Our Ref: 21/1274/FUL

INVALID APPLICATION

PROPOSAL: Installation of new metal ramp in front garden at 9 Lochar Court, Dumfries
LOCATION: 9 Lochar Court, Locharbriggs, Dumfries, DG1 1US

Site Block Layout Plan - 1-500
1 : 500

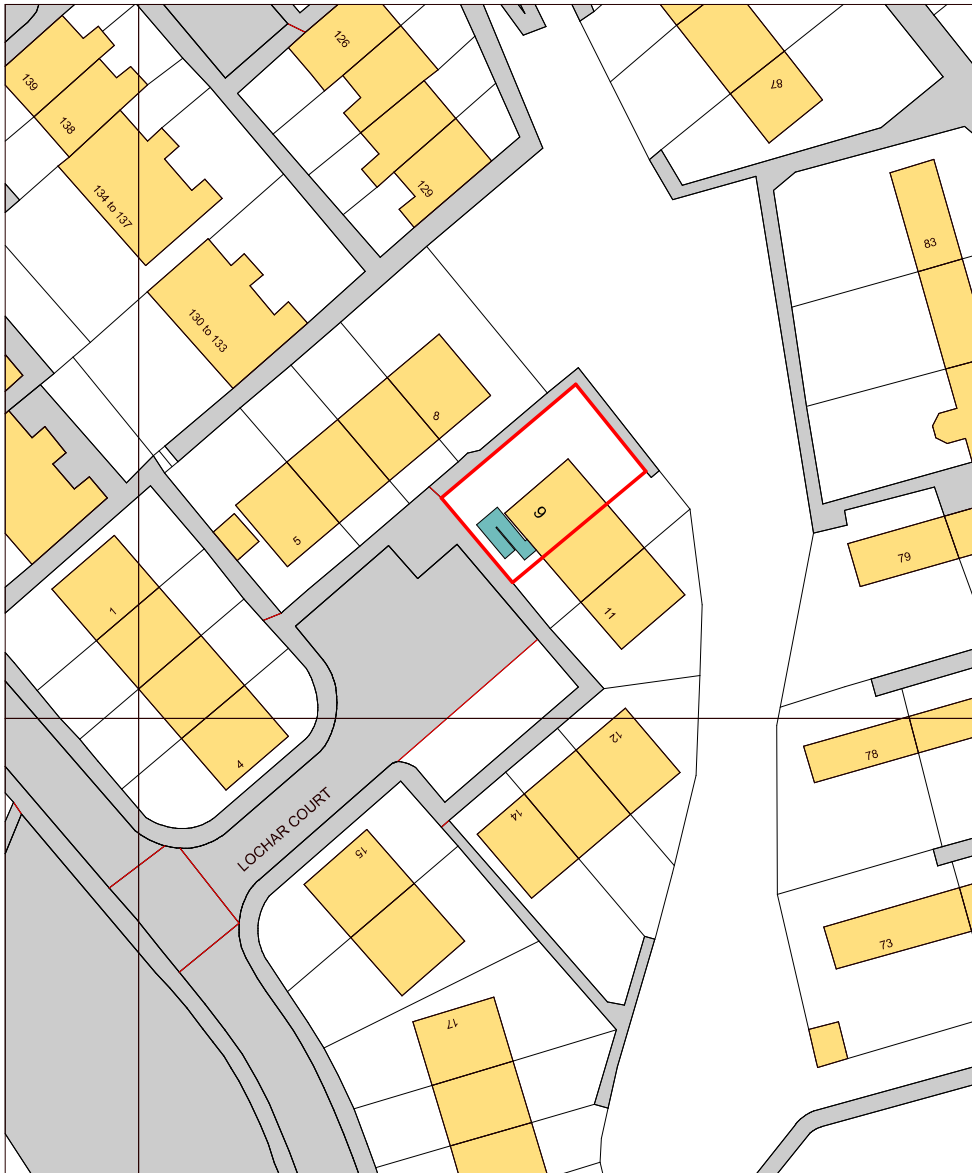
01. Please show the location of the proposed ramp on the Site/ Block/Layout Drawing and re-submit.
